Your ref:
Our ref: 21/00979/F
Please ask for: Mrs Rebecca Bush
Direct dial: 01553 616825
Direct fax: 01553 616652
E-mail: borough.planning@west-norfolk.gov.uk

Details: **Extension and loft conversion at Cassiobury 31 The Green North Runcton
King's Lynn Norfolk**

I have received a planning application as detailed above but cannot process it until I receive some more information:

Proposed Elevations

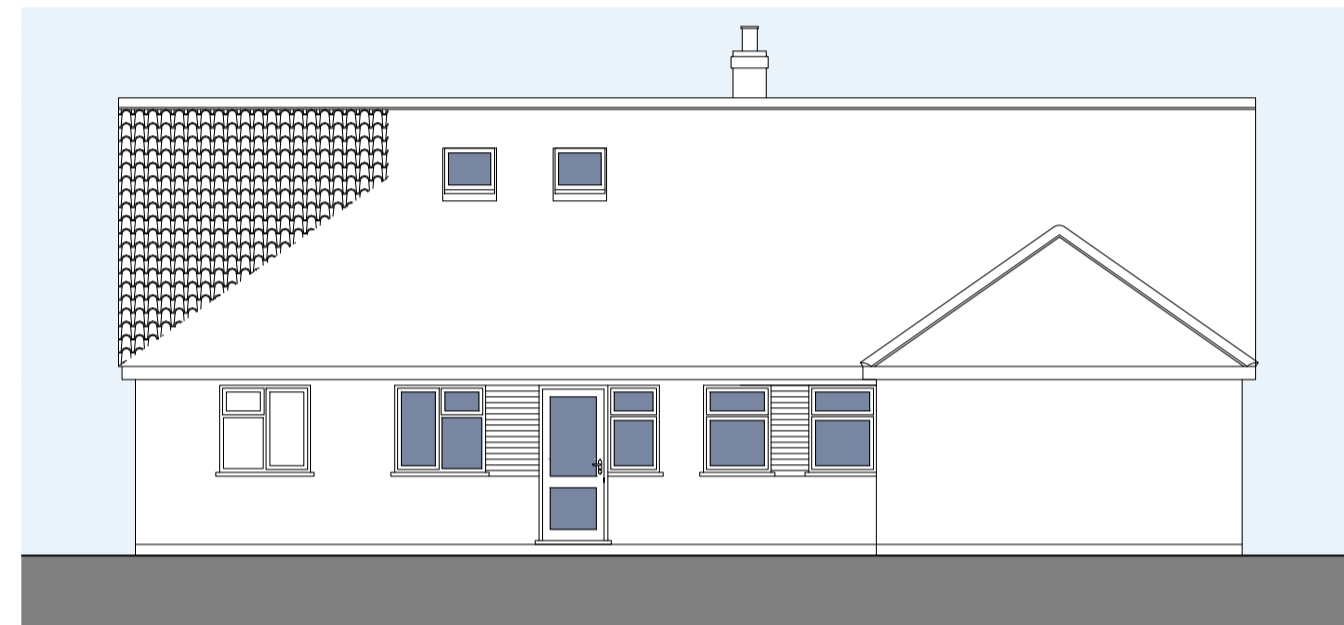
1. The proposed north elevation shows 2 roof lights however the roof plan only shows one, please amend where necessary.
2. As the property lies within an area at risk to flooding, please complete the simplified Matrix and return it. The Matrix can be found at https://www.west-norfolk.gov.uk/info/20173/information_for_planning_agents/231/flood_risk_information
